**KIRKLEES METROPOLITAN COUNCIL
INVESTMENT & REGENERATION SERVICE**

DELEGATED DECISION TO DETERMINE PLANNING APPLICATIONS

Reference No:	2023/62/92928/E
Site Address:	Land at, Taylor Hall Lane, Mirfield, WF14
Description:	Erection of 4 dwellings
Recommending Officer:	Nicole Helliwell

Officer Report

1 Proposed South-West (Front) Street Elevation

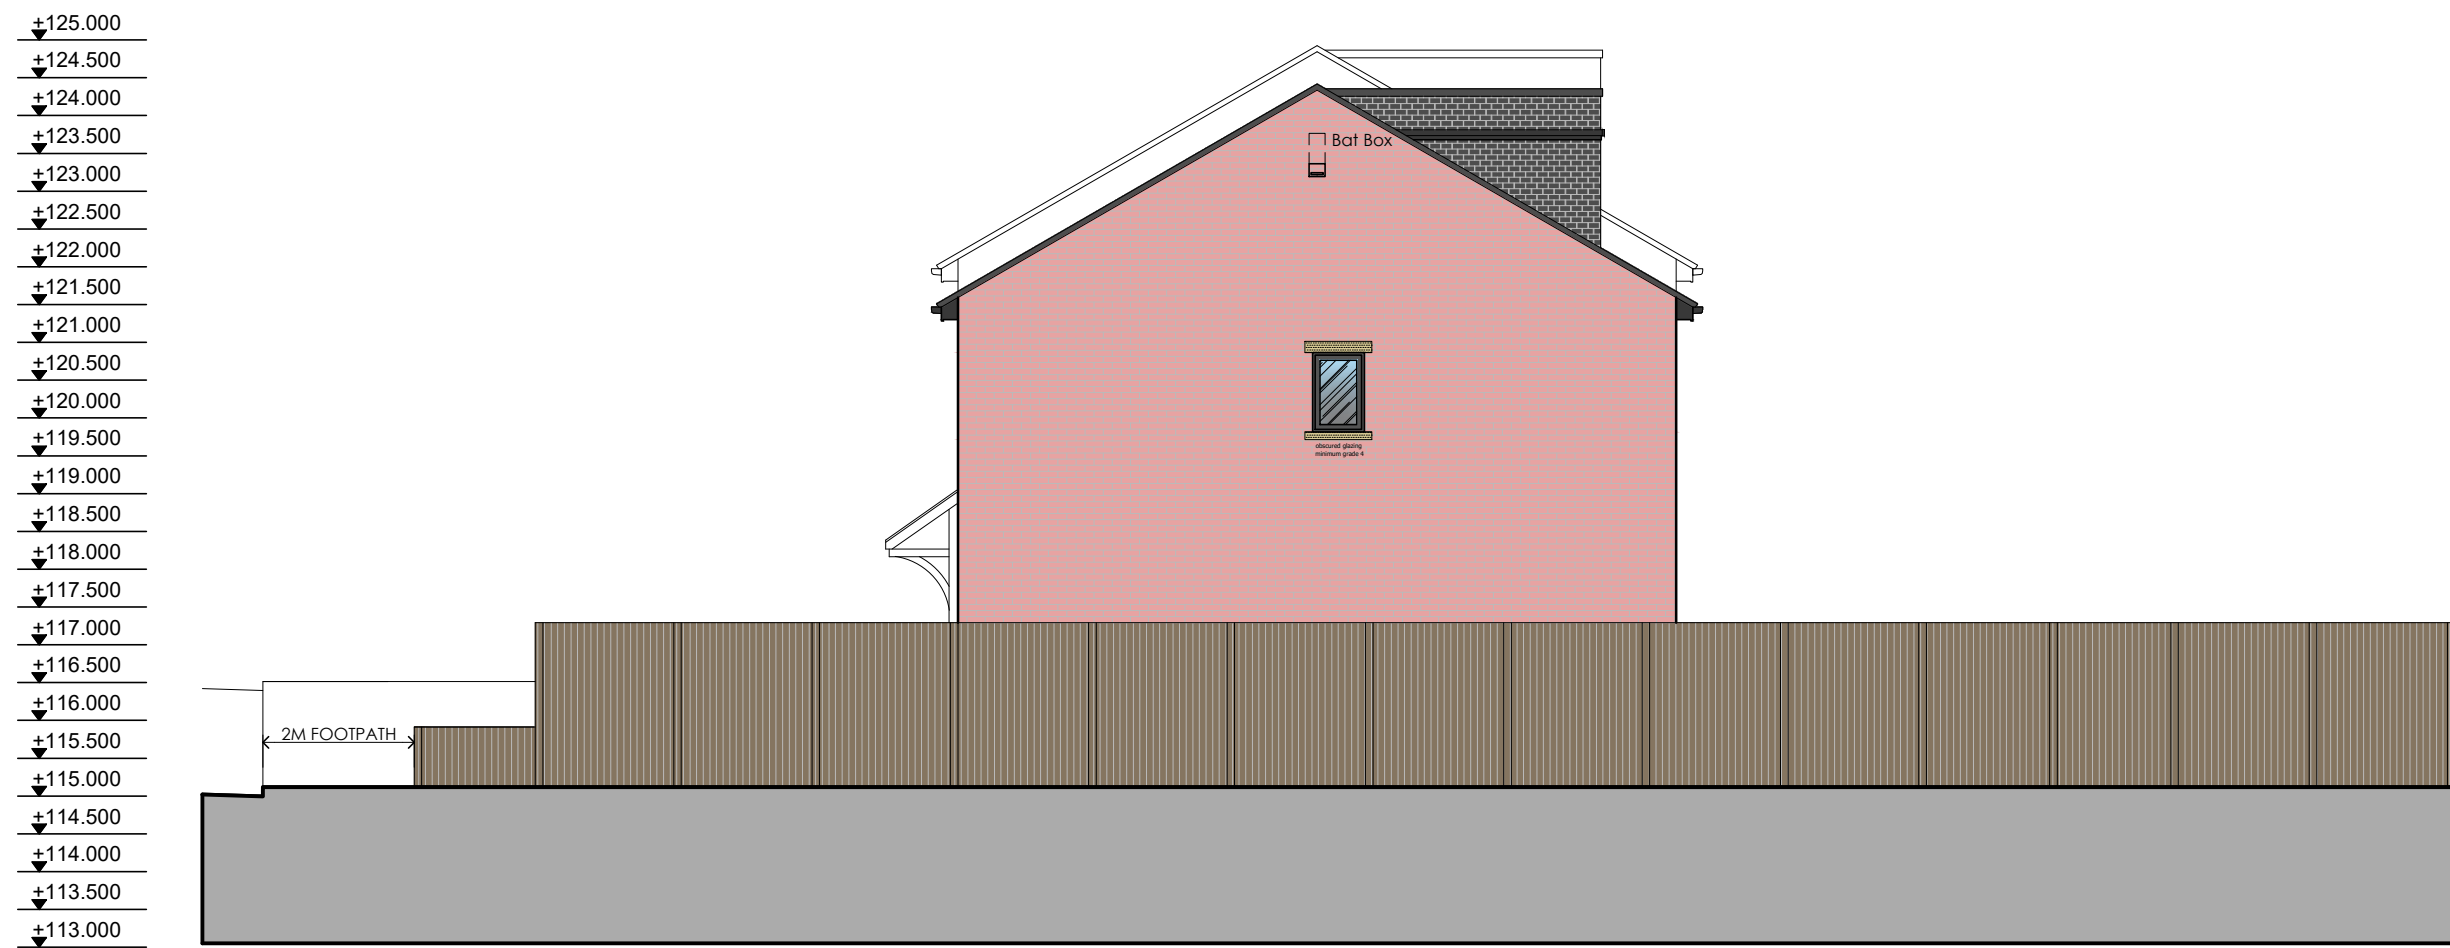
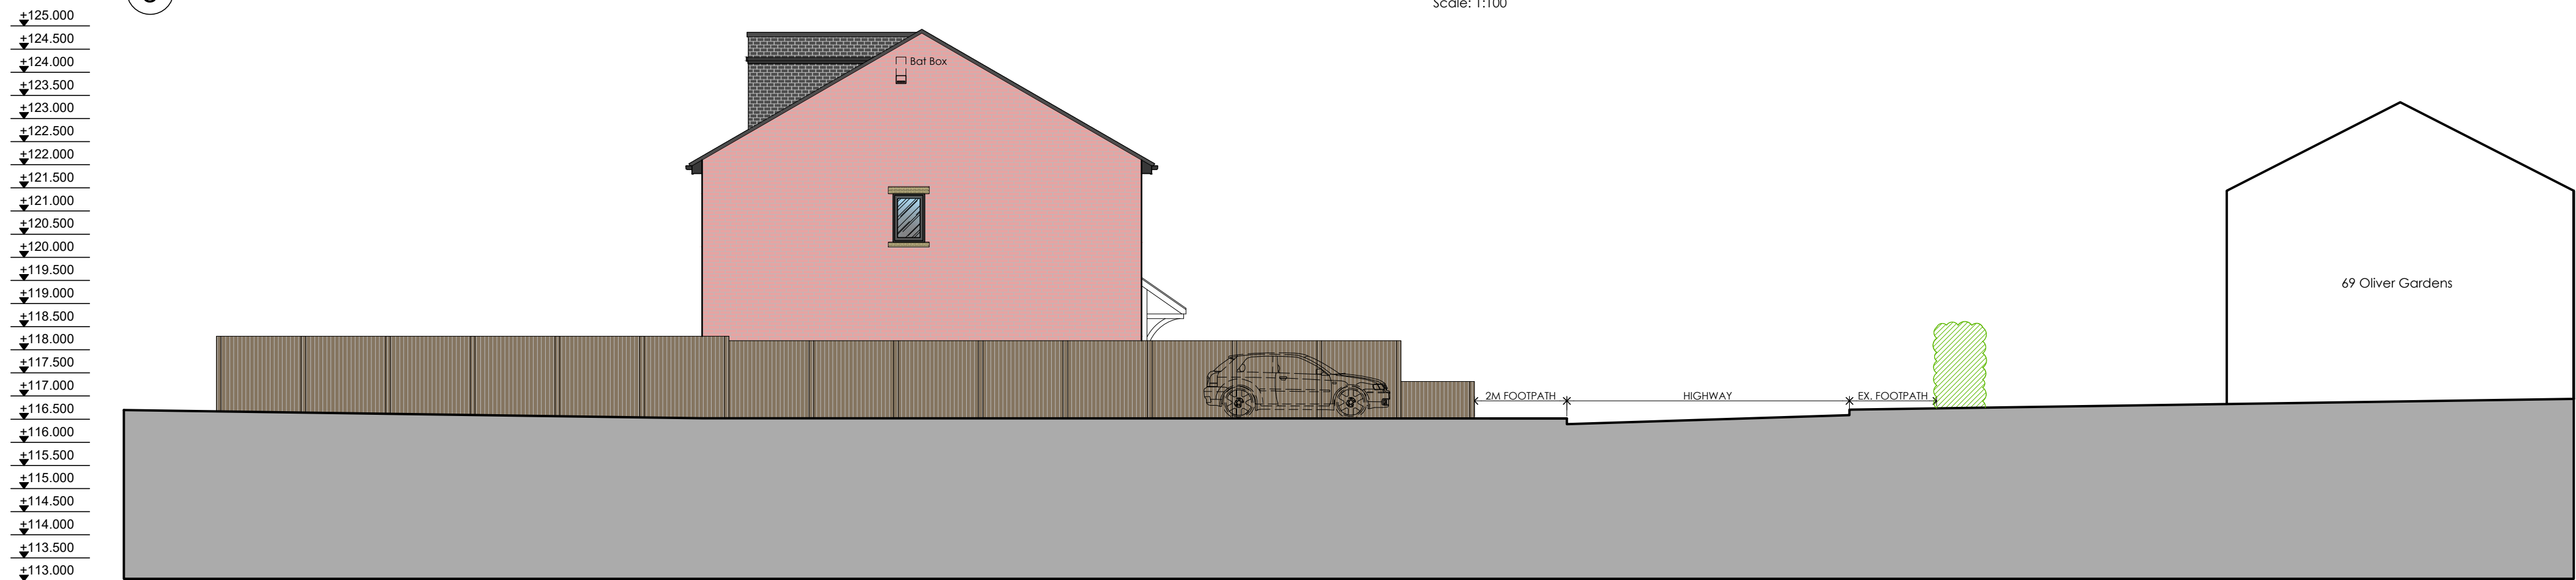
The proposed dwellings would be three storeys in height and would be of a traditional design. The properties would be constructed in red brick with artificial stone heads and cills and would incorporate dual-pitched roofs finished in grey concrete tiles. The property would also incorporate grey PVC windows and doors and it is noted that the arrangement of fenestration and openings would be typical of this style of dwelling. On this basis, it is considered that the dwellings would not appear discordant and would harmonise well into the surrounding townscape.

The submitted plans and application form provide limited information regarding the proposed boundary treatments. Therefore, in the interest of visual amenity and to ensure that a satisfactory appearance of development is achieved upon completion, a condition will be imposed requiring details of the position, height, and materials of all boundary treatments to be submitted to and approved in writing by the Local Planning Authority.

3. The semi-detached dwellings hereby approved shall be faced in red brick for the external walls with artificial stone heads and sills and grey concrete tiles for the roofs. The materials of construction shall thereafter be retained for the lifetime of the development.

5. Notwithstanding the submitted plans and information, before development commences on the superstructure of the dwellings hereby approved, full details of all boundary treatments shall be submitted to and approved in writing by the Local Planning Authority. The development shall thereafter be completed in accordance with the approved details before the dwellings are first brought into use and thereafter retained.
